Consultation Response from: KC Environmental Health (Pollution & Noise Control)		
2021/93574 Lockwood Road, Lockwood, Huddersfield		
Change of use to form no. 2 hot food takeaways (Sui Generis) at ground floor with ancillary office and store at first floor and sub division of first floor apartment to form no. 3 dwellings (C3)		
Responding Date: 1 st December 2021	Responding Officer: Shirley Reynolds	Responding Ref: WK/202135862
<u>Comments</u> We have reviewed this application and make the following comments and recommendations. Odours The application is for a change of use to provide 2 hot food take away units with residential accommodation to the first floor above. Our concern is with odours and noise caused during the food preparation and cooking process and the impact that this will have on the amenity of the residents living near to the development and future residents of the proposed accommodation above. No detailed information has been submitted regarding the proposed kitchen extract ventilation system, including measures to control odours and noise and how this is to be maintained. Therefore, it will be necessary for a condition to control the noise and odours relating to t

PROPOSED GROUND FLOOR PLAN

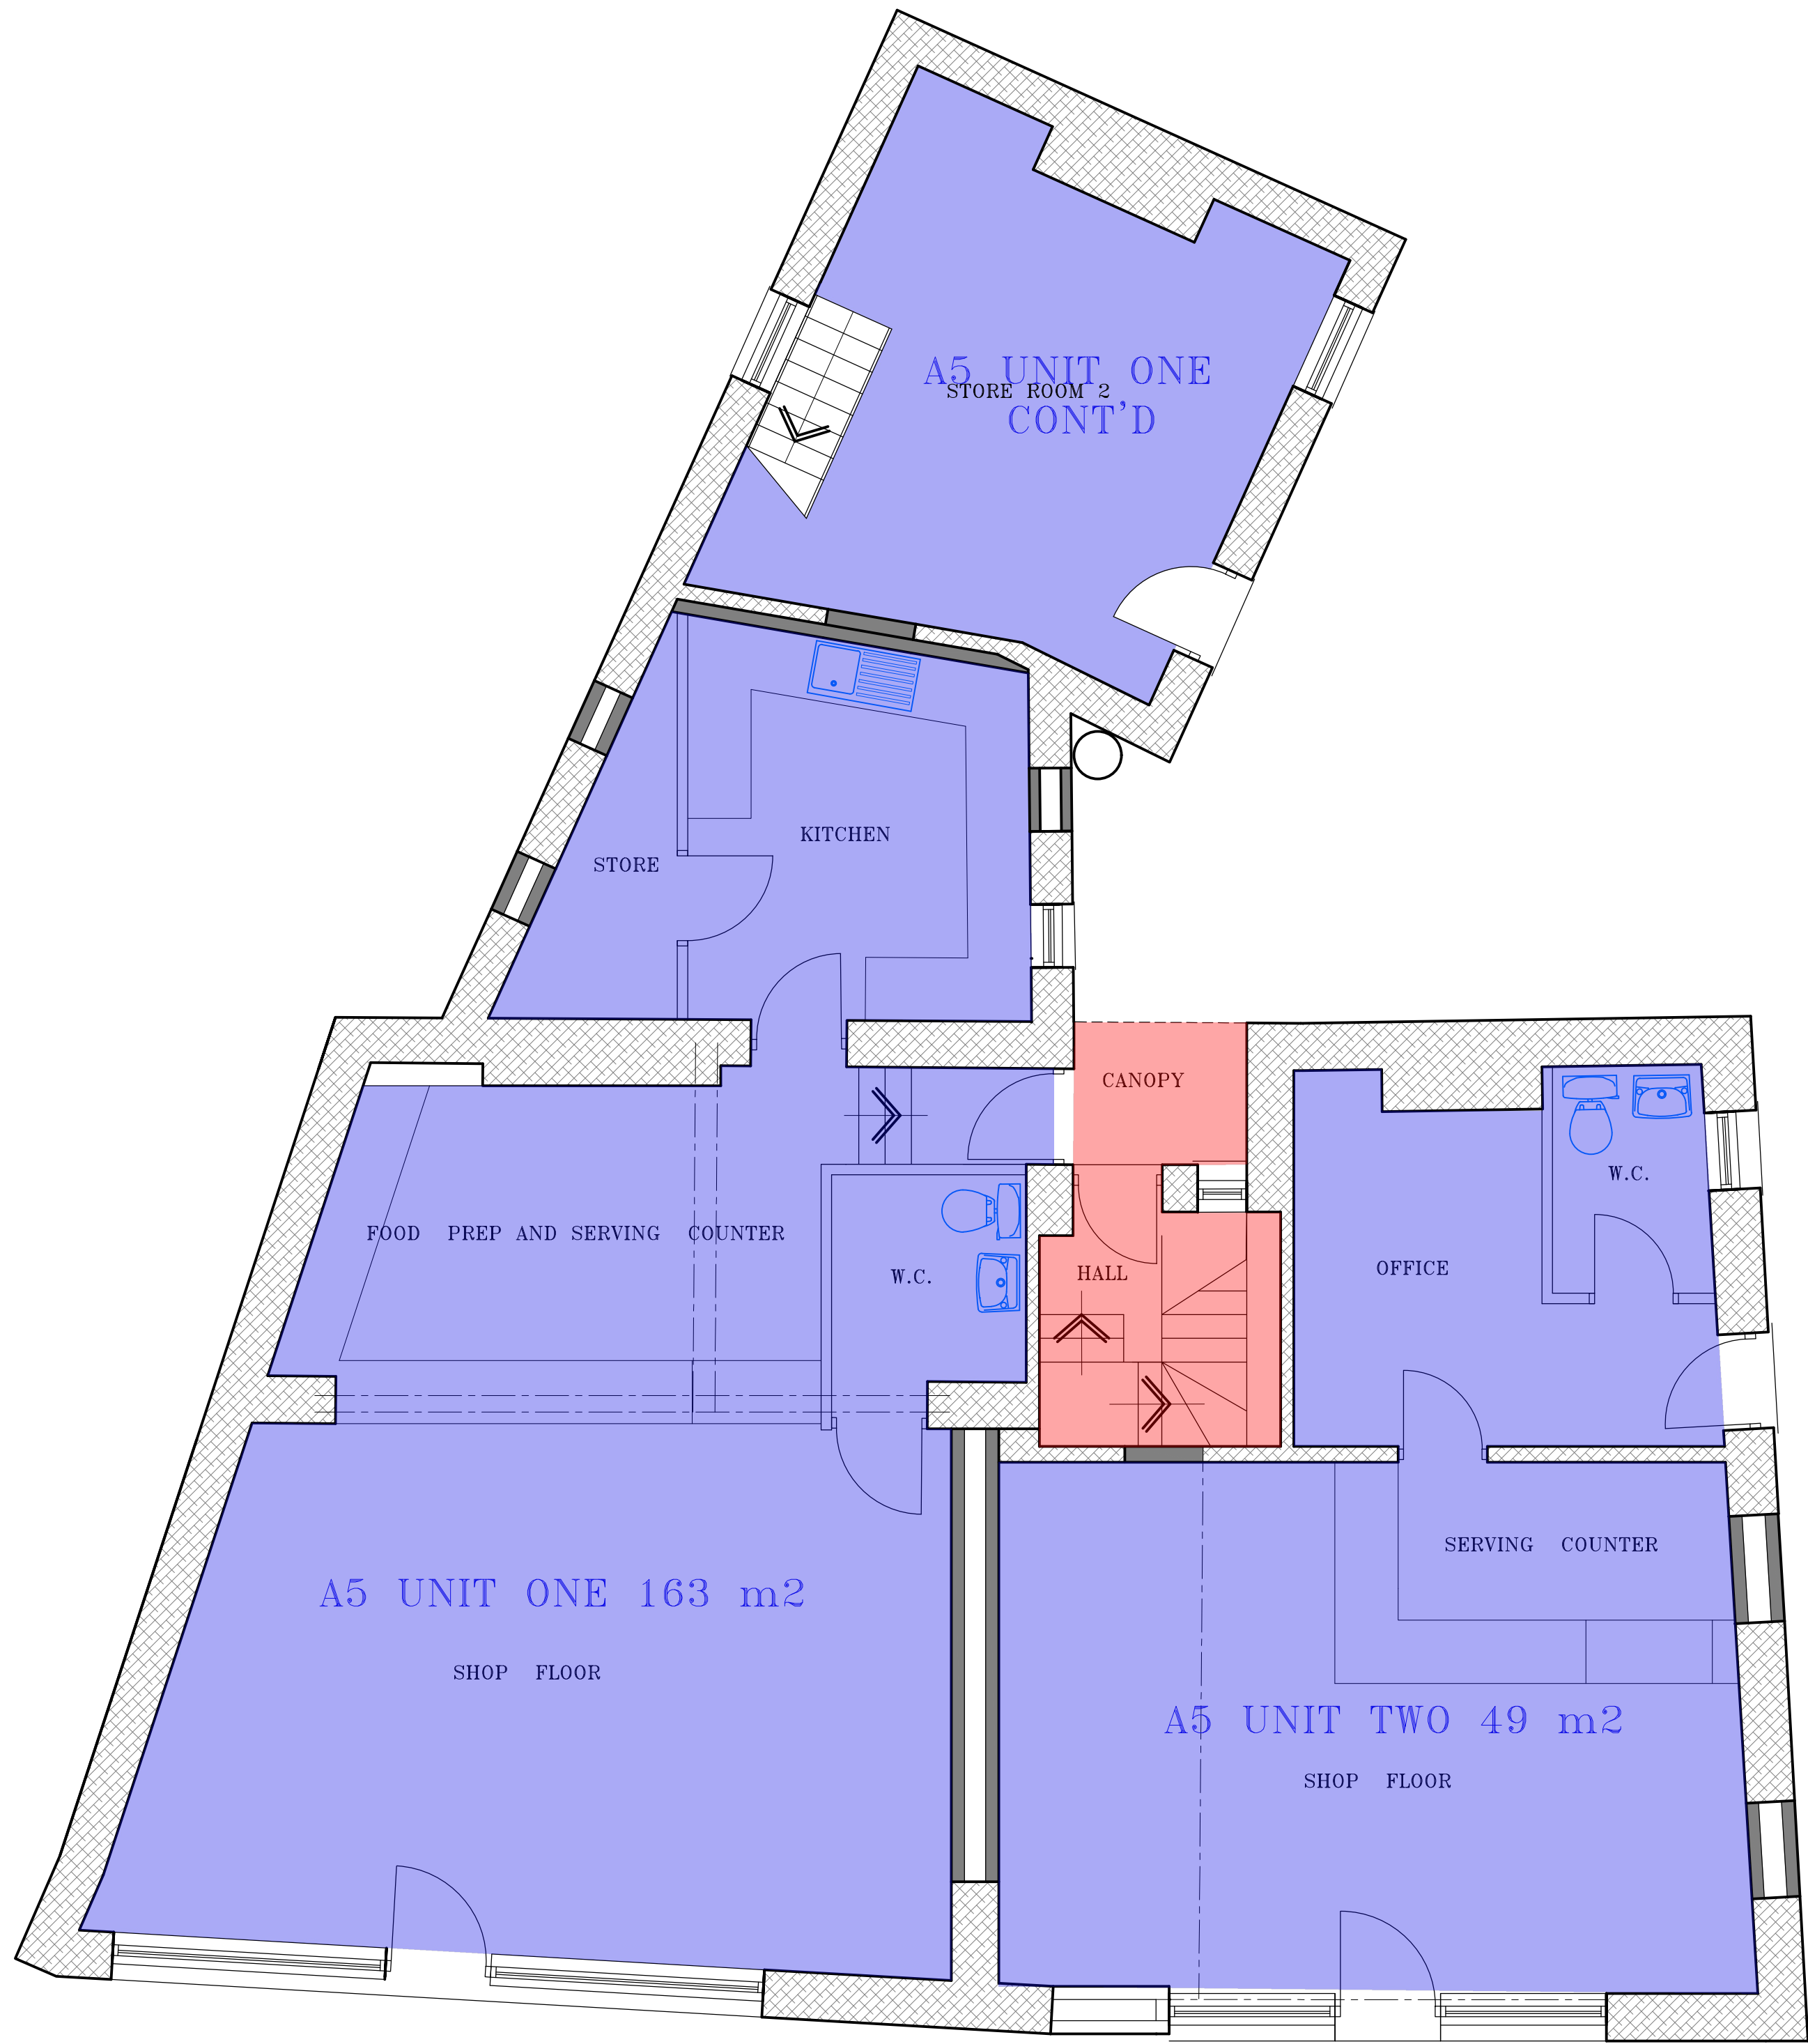
Prior to development commencing the applicant should supply details of the intervening ventilated spaces (IVS), that will be provided to the toilet accommodation in the proposed food units or provide details of why these IVS spaces are not required.
